GOVERNMENT ARCHITECT NEW SOUTH WALES

PROJECT: Pathways Cremorne Seniors
RE: State Design Review Panel – 8th February 2023 – Review 1

PROJECT: Pathways Cremorne Seniors
RE: State Design Review Panel – 17th May 2023 – Review 2

1 BASEMENT 02

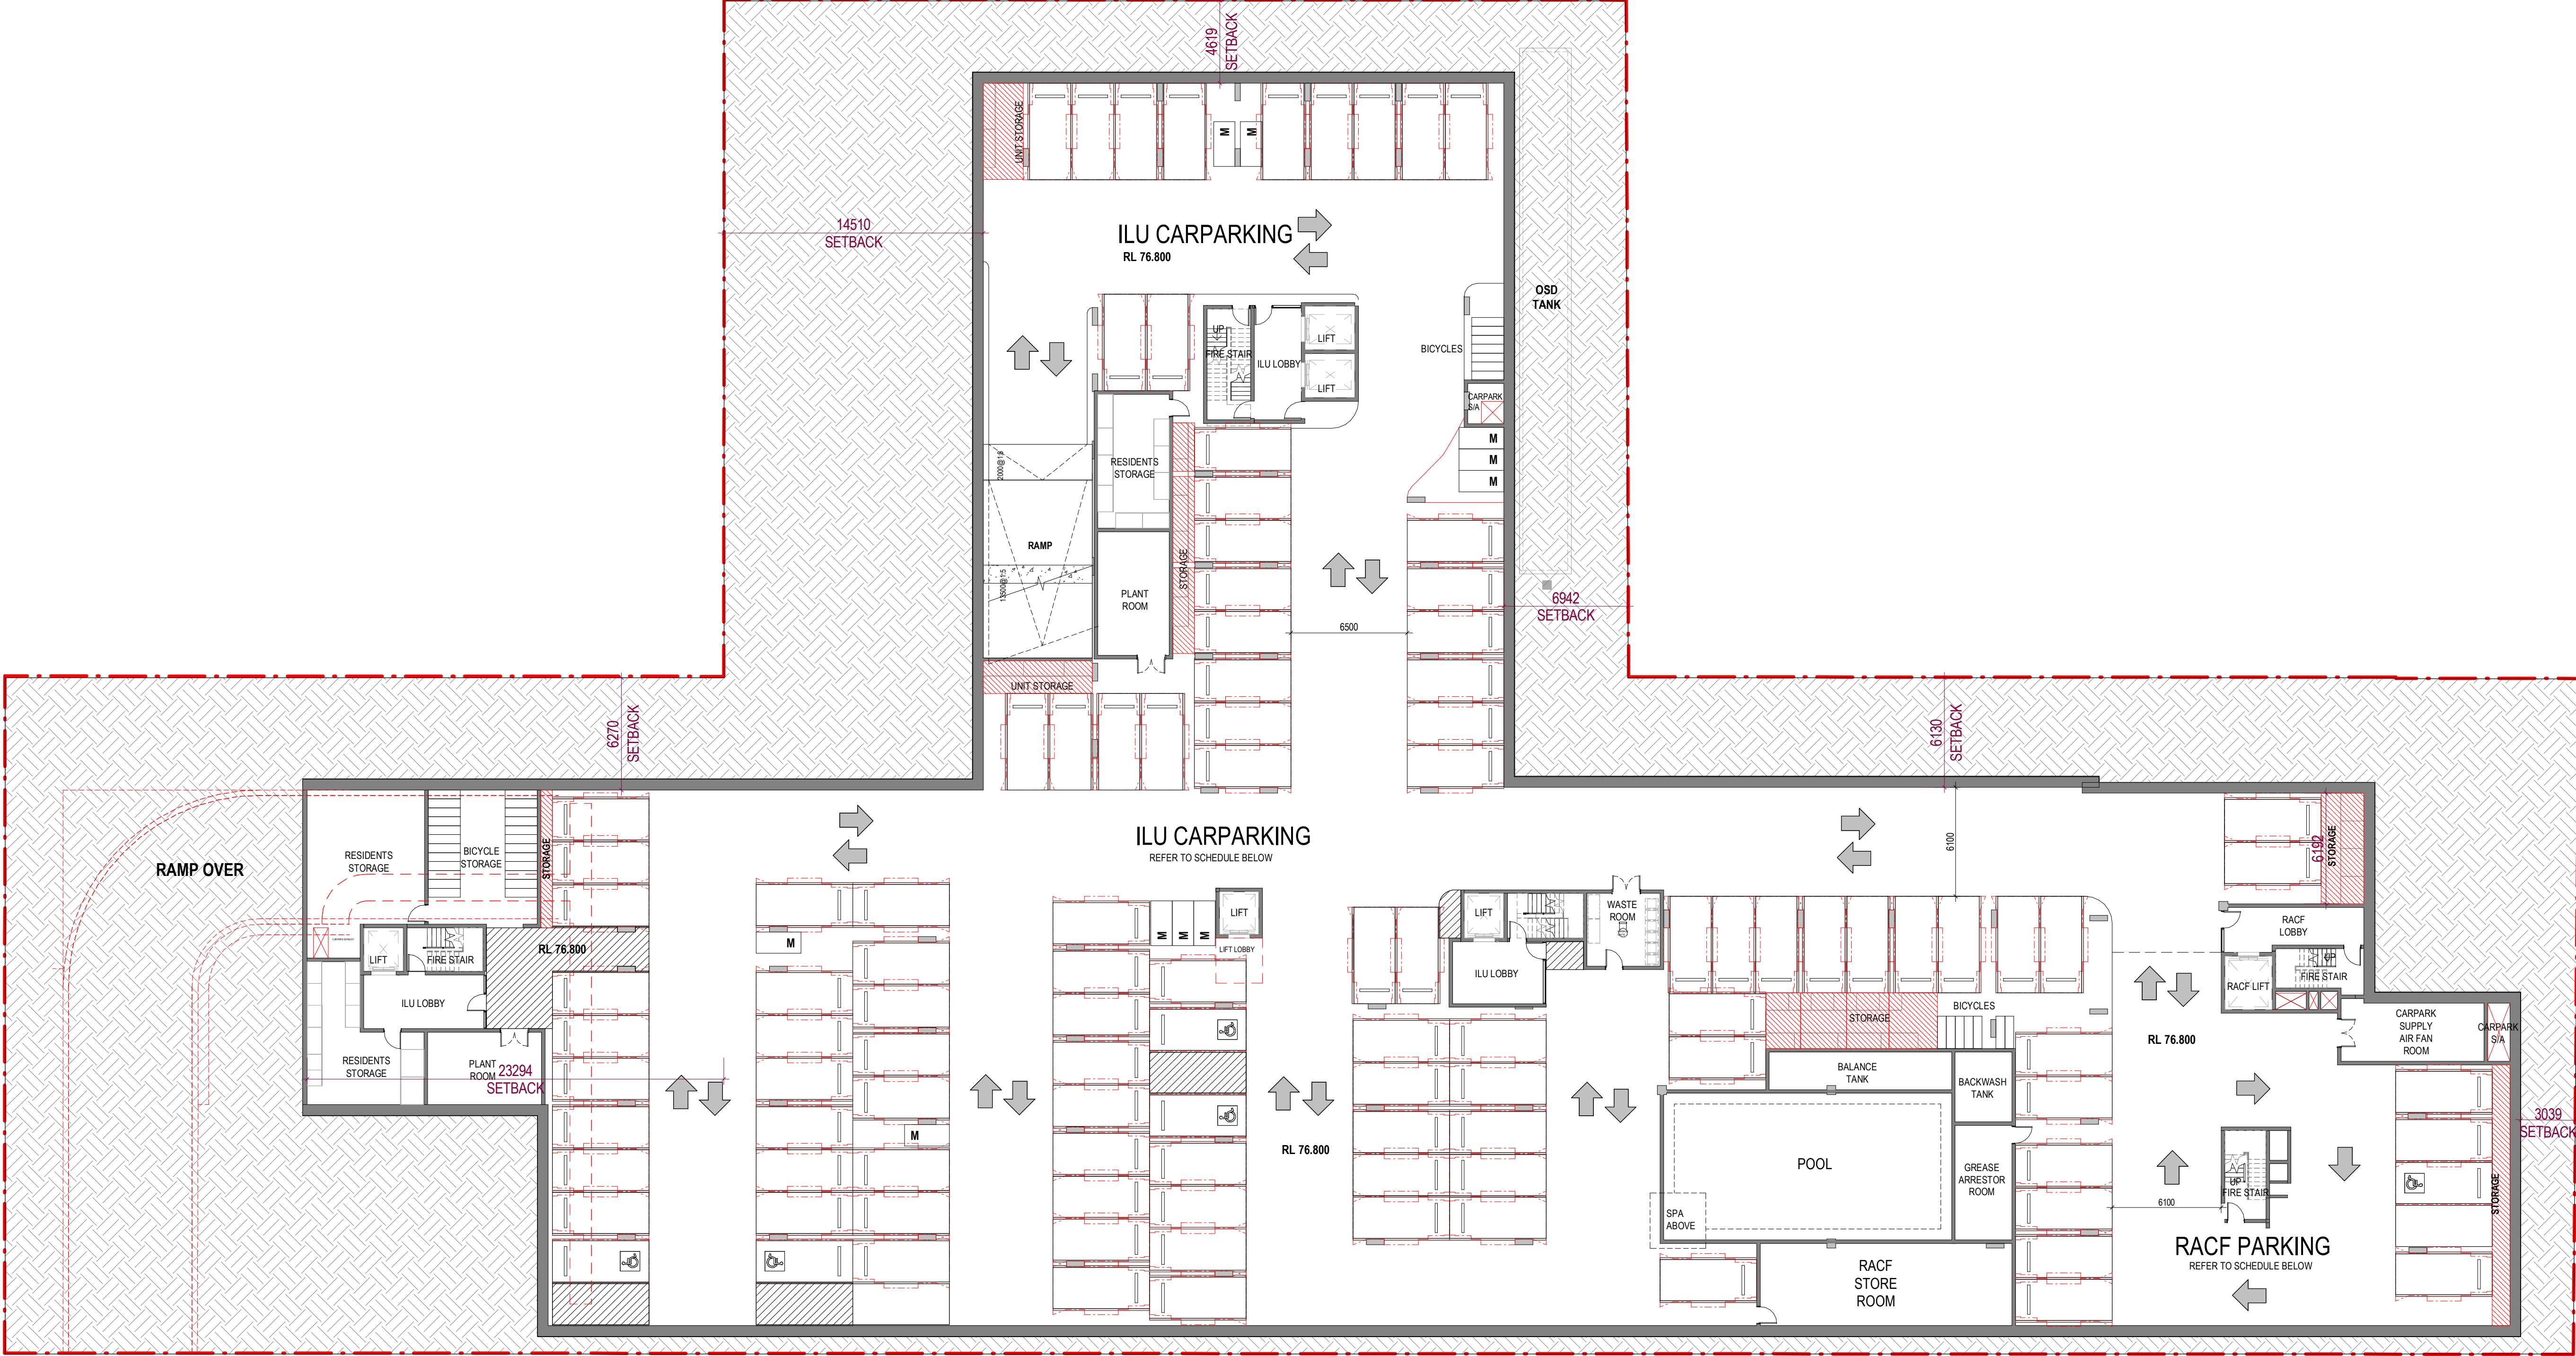
As per previous advice, locating the common amenities in the basement is sub-optimal as the main access from the ILUs is shared with the basement car park and loading dock which is potentially hazardous and unpleasant. In addition, the only outlook from the common amenities is to Ferntree Gully and a boundary retaining wall.

The logic of underpinning the existing cottages to create these spaces, and especially the long spans for the pool, is also questioned, particularly as most of the proposed uses are better suited to ground level locations that are easier to access and have better natural light and ventilation.

14. Reconfigure the basement to achieve the following:

- a. relocate the bar, salon and restaurant to the ground floor and reduce extent of excavated area;
- b. reduce the parking provision to meet minimum standards, and limit the basement to a single storey, to minimise excavation
- c. provide for deep soil zones to create better conditions for tree canopy to establish at the southern end of the through site link.

1 SITE PLAN - DEEP PLANTING

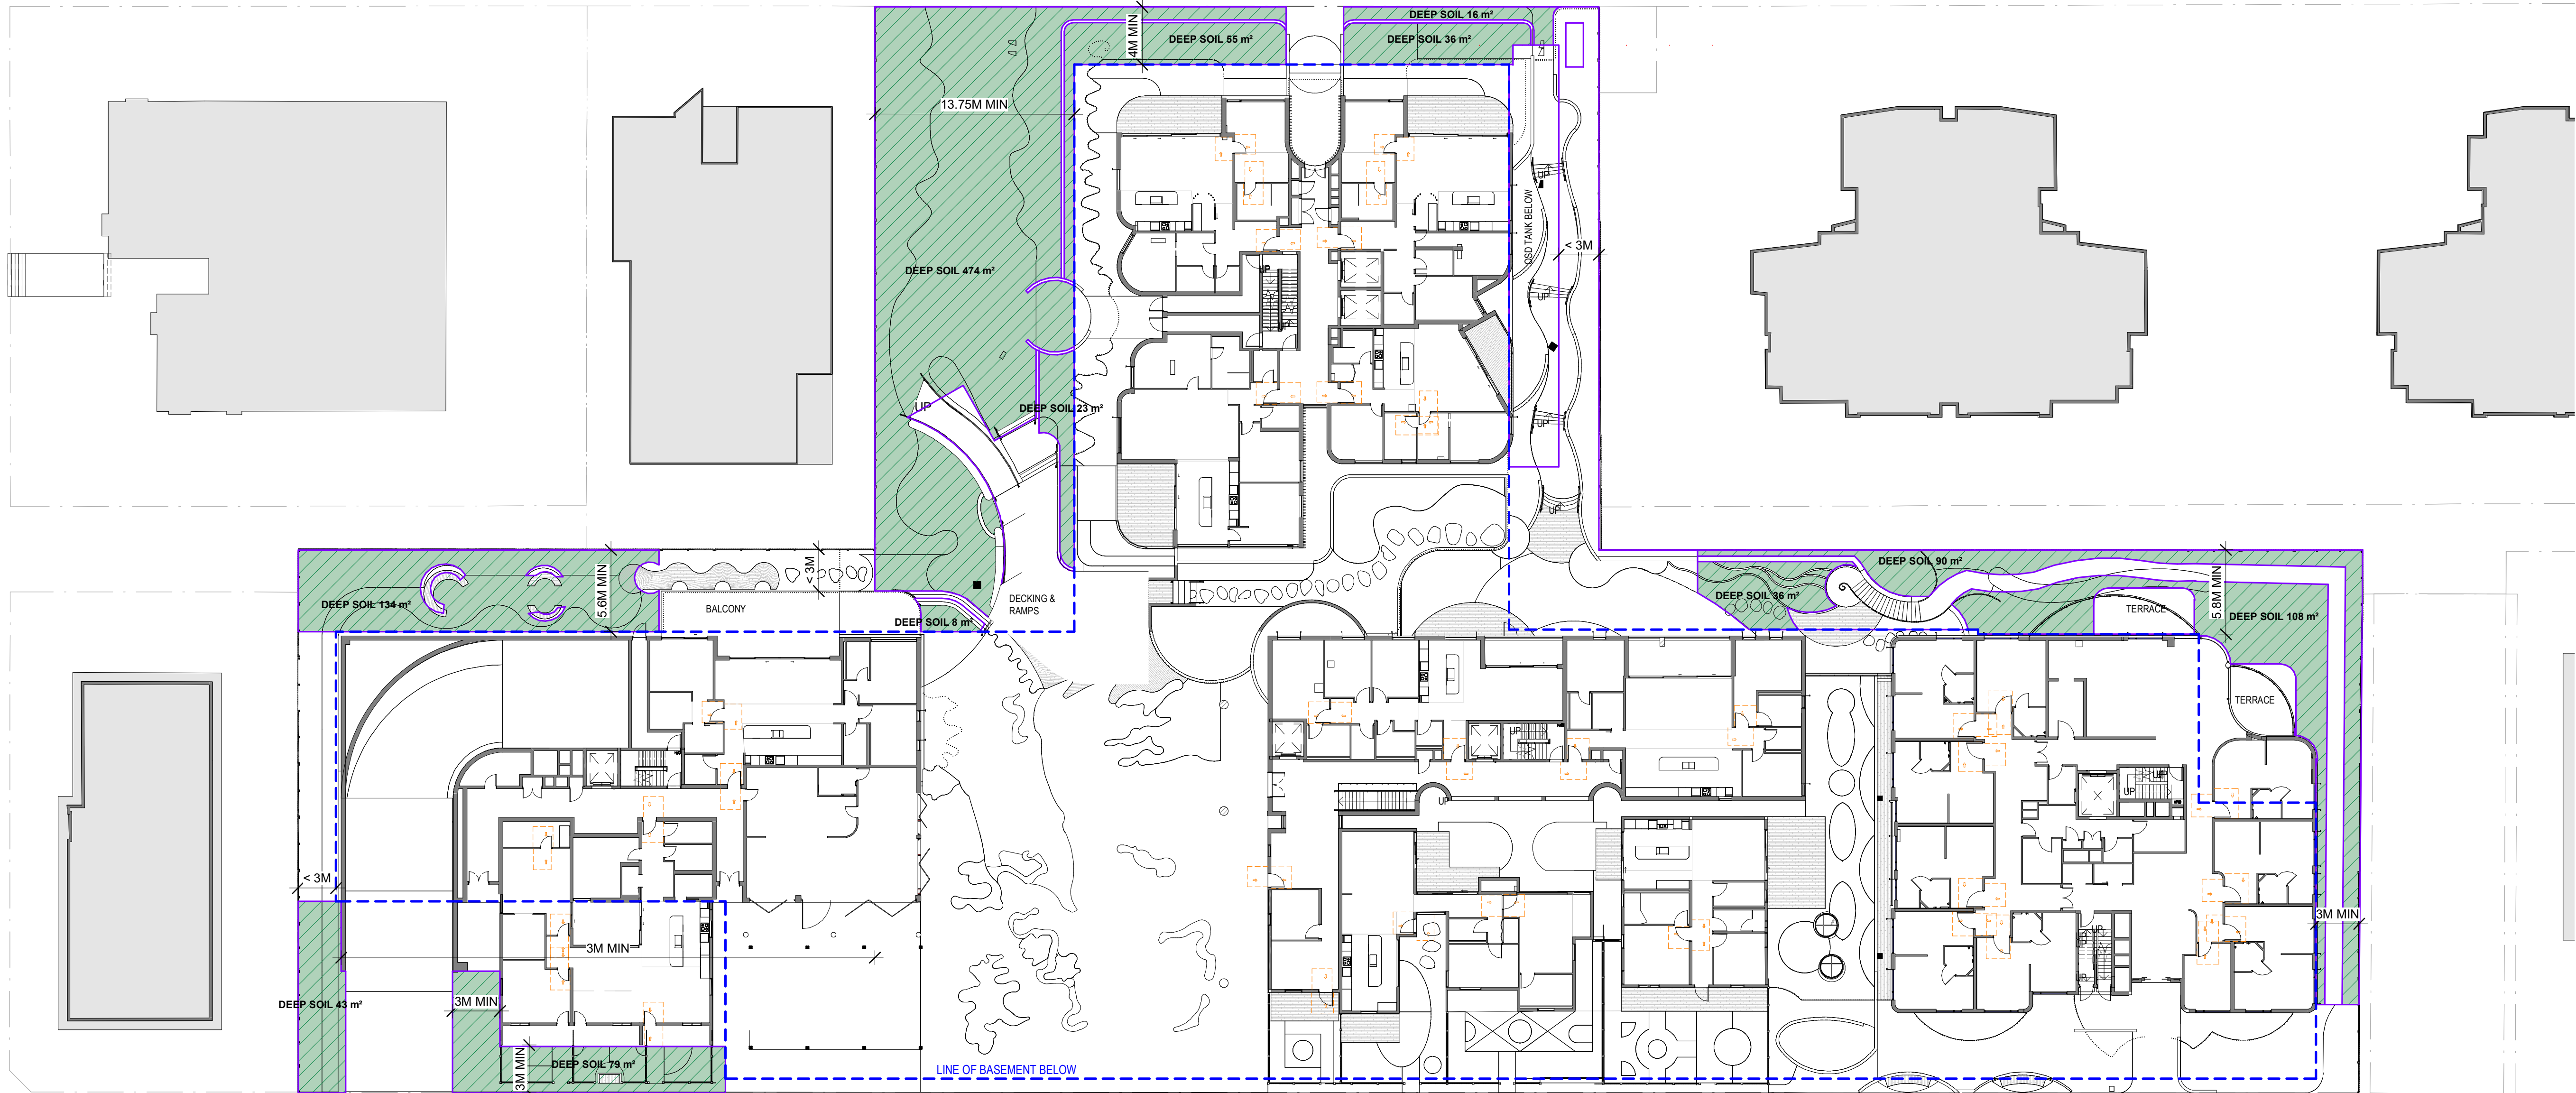
3. The basement occupies much of the site, leaving the narrower perimeter areas with least amenity as the only deep soil available to support substantial planting.

- a. As noted elsewhere, review the extent and layout of the basement to create more opportunities for deep soil at the centre of the site.
 - b. As noted elsewhere, develop landscape strategies that optimise the limited amenity of the perimeter zones - considering a range of uses that complement adjacent building uses.

SKETCH DETAIL of fence type F1 as it traverses the through site link

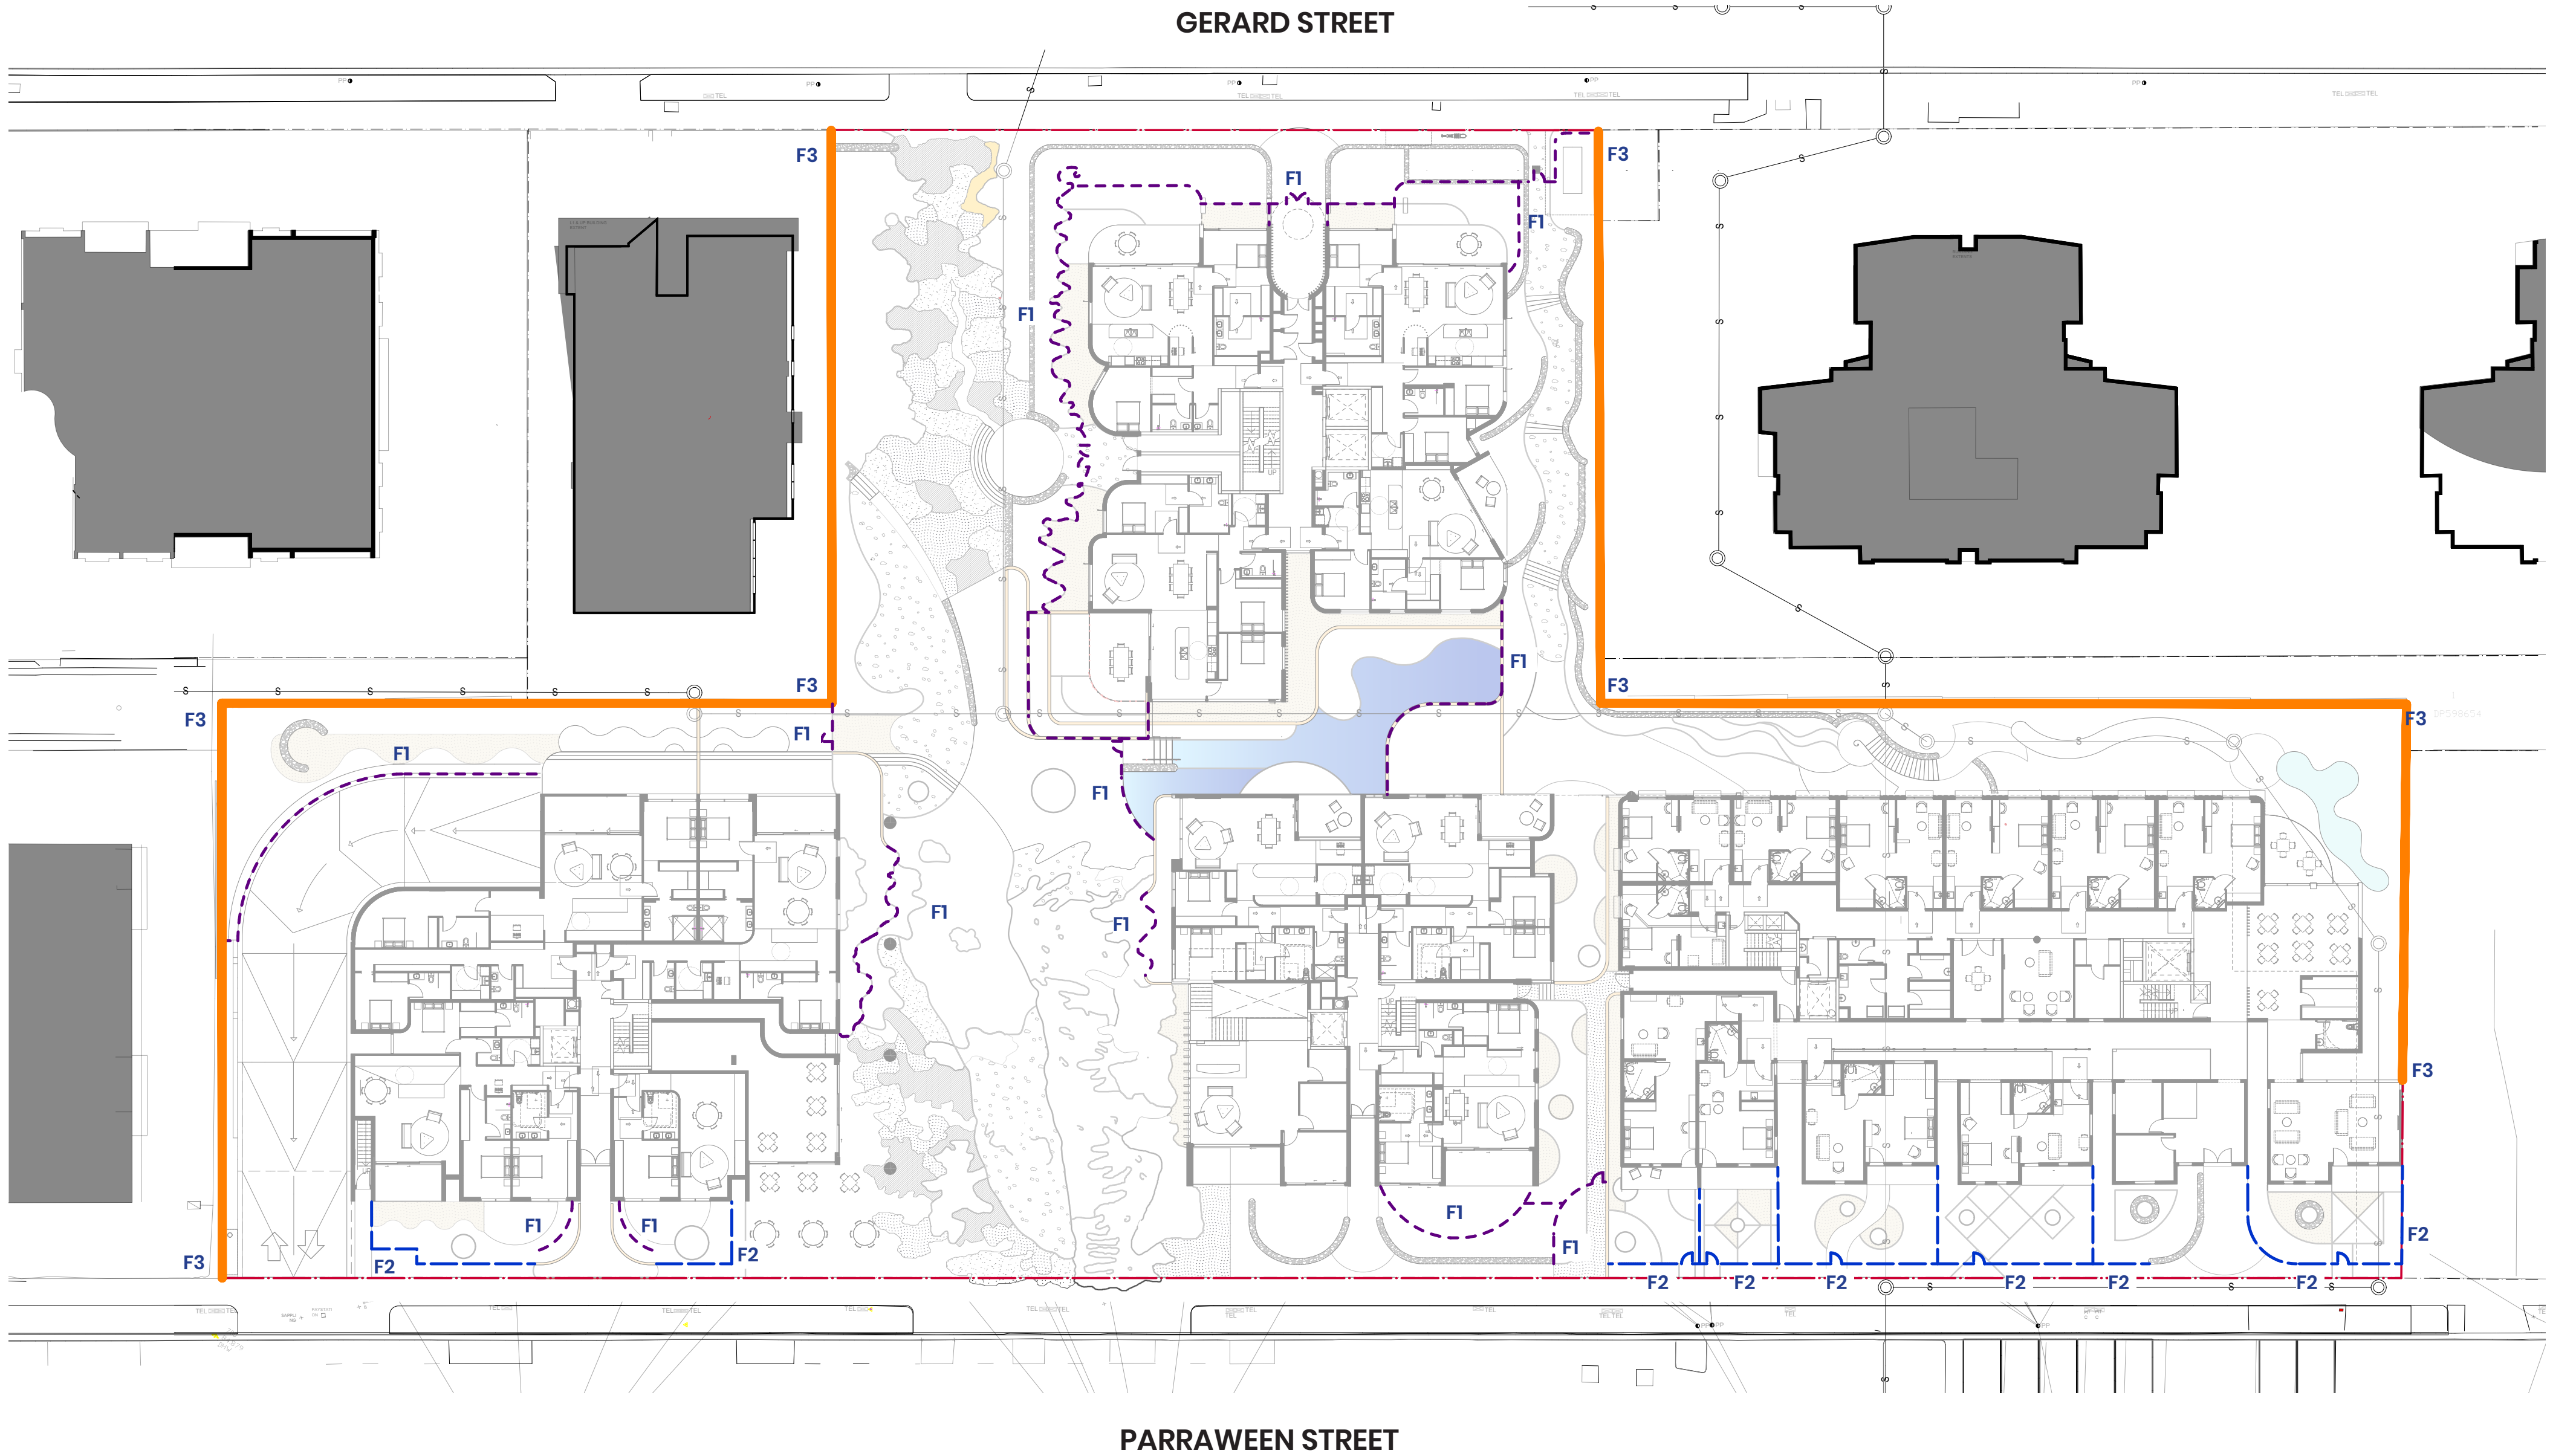
4. While the public through-site link is supported, there is still ambiguity around the differentiation of public space from semi-private and private space along its edges. Ensure that:

- a. the link is legible as public space, and clearly delineated in relation to private and communal spaces
 - b. sightlines from Parraween St through to and down Ada St are unobstructed, as noted above.
